Re: Advice on Modification Report – Maryvale Solar Farm MOD 1 - Battery Energy Storage System (SSD-8777-Mod-1).

Fire and Rescue NSW (FRNSW) acknowledge correspondence received on the 20th January 2022, requesting Advice on the Modification Report for **Maryvale Solar Farm MOD 1 - Battery Energy Storage System (SSD-8777-Mod-1).**

FRNSW have reviewed the Modification Report along with Appendix F Preliminary Hazards Analysis (PHA) and make the following comments:

Figure 1 | Project Layout – Centralised BESS Option

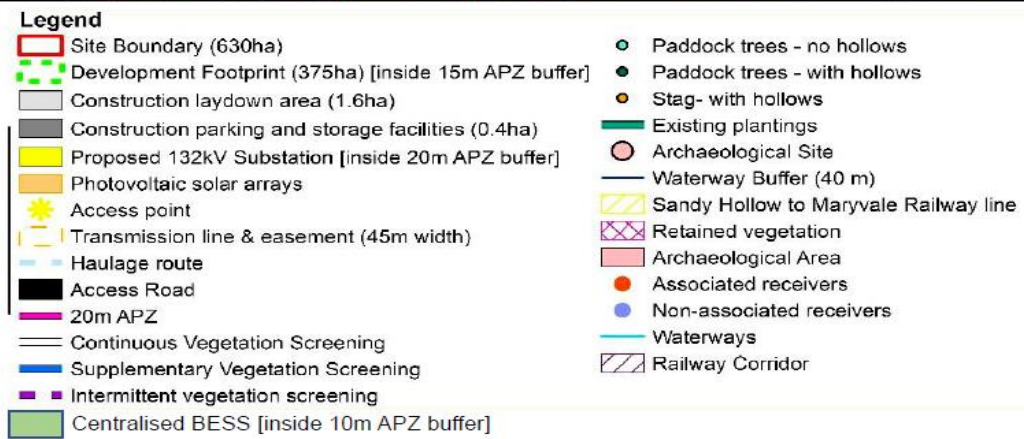
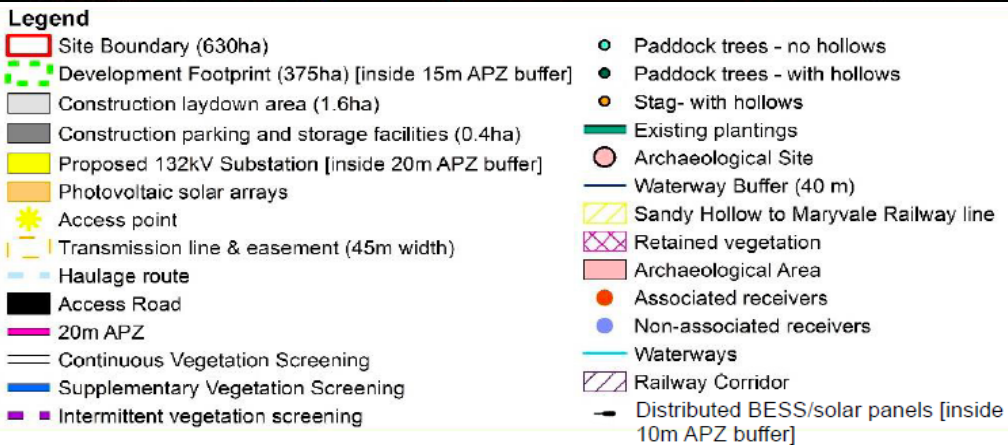
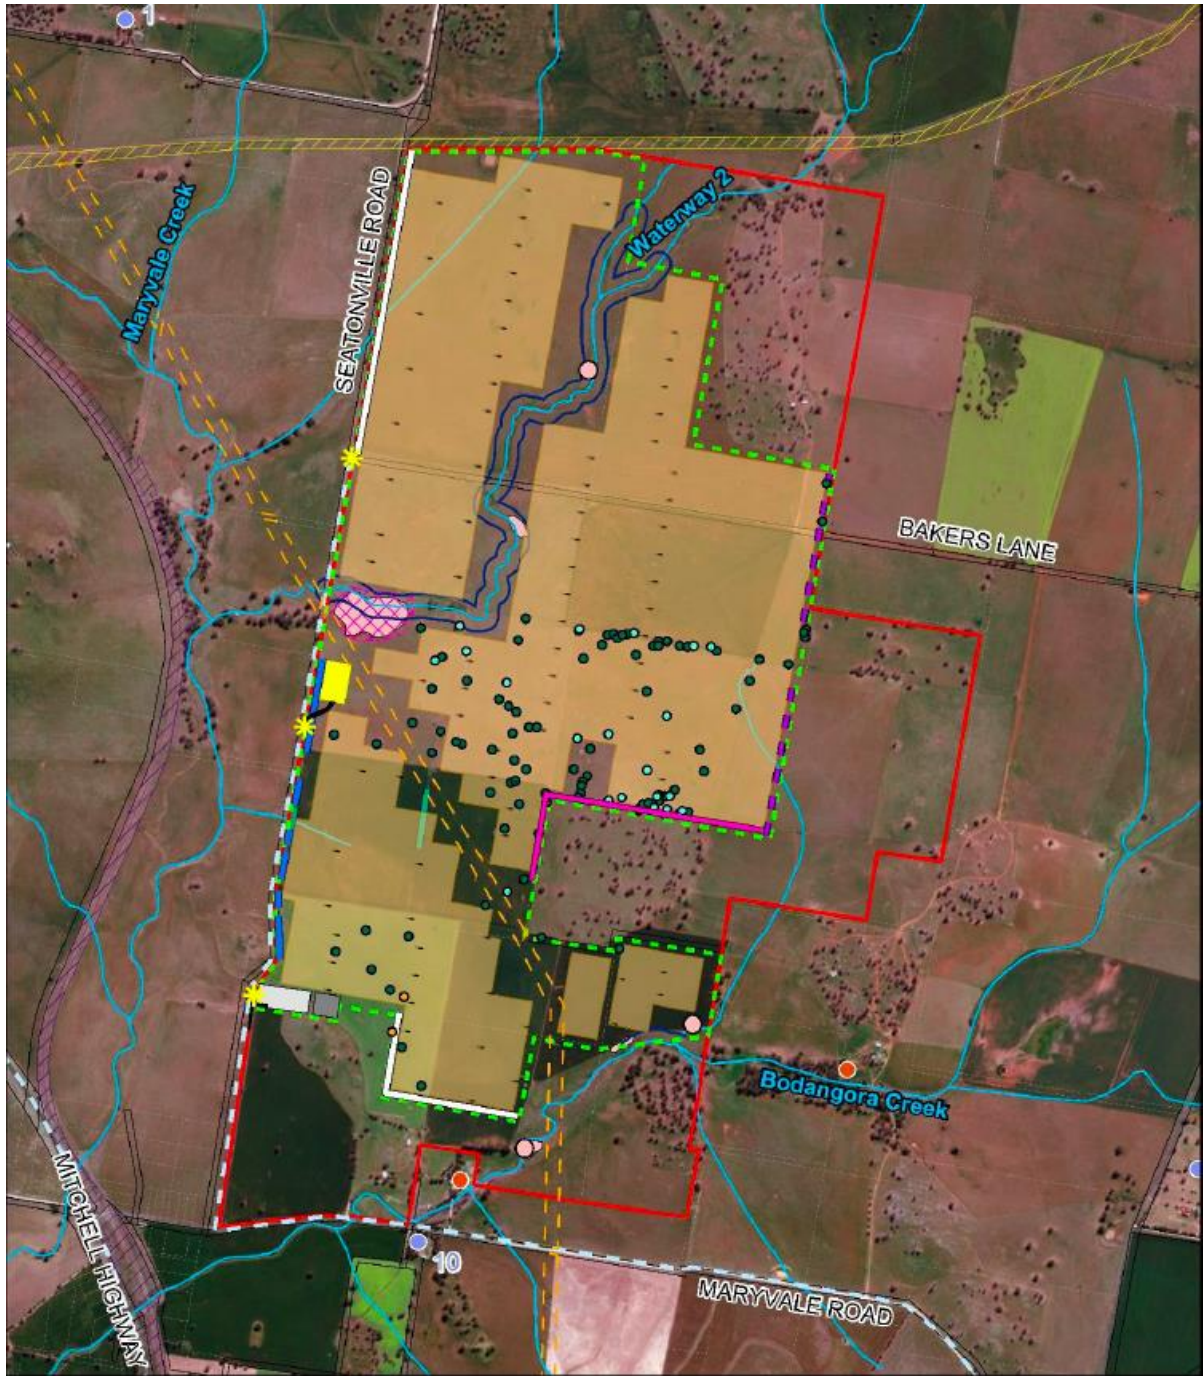
FRNSW note that detailed design of the BESS is currently unavailable and the PHA recommends that "detailed firefighting response and the need for fire water containment should be assessed and reported (e.g. in the format of a Fire Safety Study)". Further, FRNSW note the remote location of the project site, and it is our experience that water supplies for firefighting are challenging to source and access in these locations.

1. To ensure that the fire prevention, detection, protection and firefighting measures are appropriate to the specific fire hazards and adequate to meet the extent of potential fires, a comprehensive Fire Safety Study (FSS) is recommended to be undertaken.
2. That the FSS is developed in accordance with the requirements of Hazardous Industry Planning Advisory Paper No.2 (HIPAP No.2).

3. That the FSS is required to be developed to the satisfaction of the operational requirements of FRNSW. FRNSW recommend that the development of a FSS be a condition of consent.
4. That the development of the FSS considers the operational capability of local fire agencies and the need for the facility to achieve an adequate level of on-site fire and life safety independence.
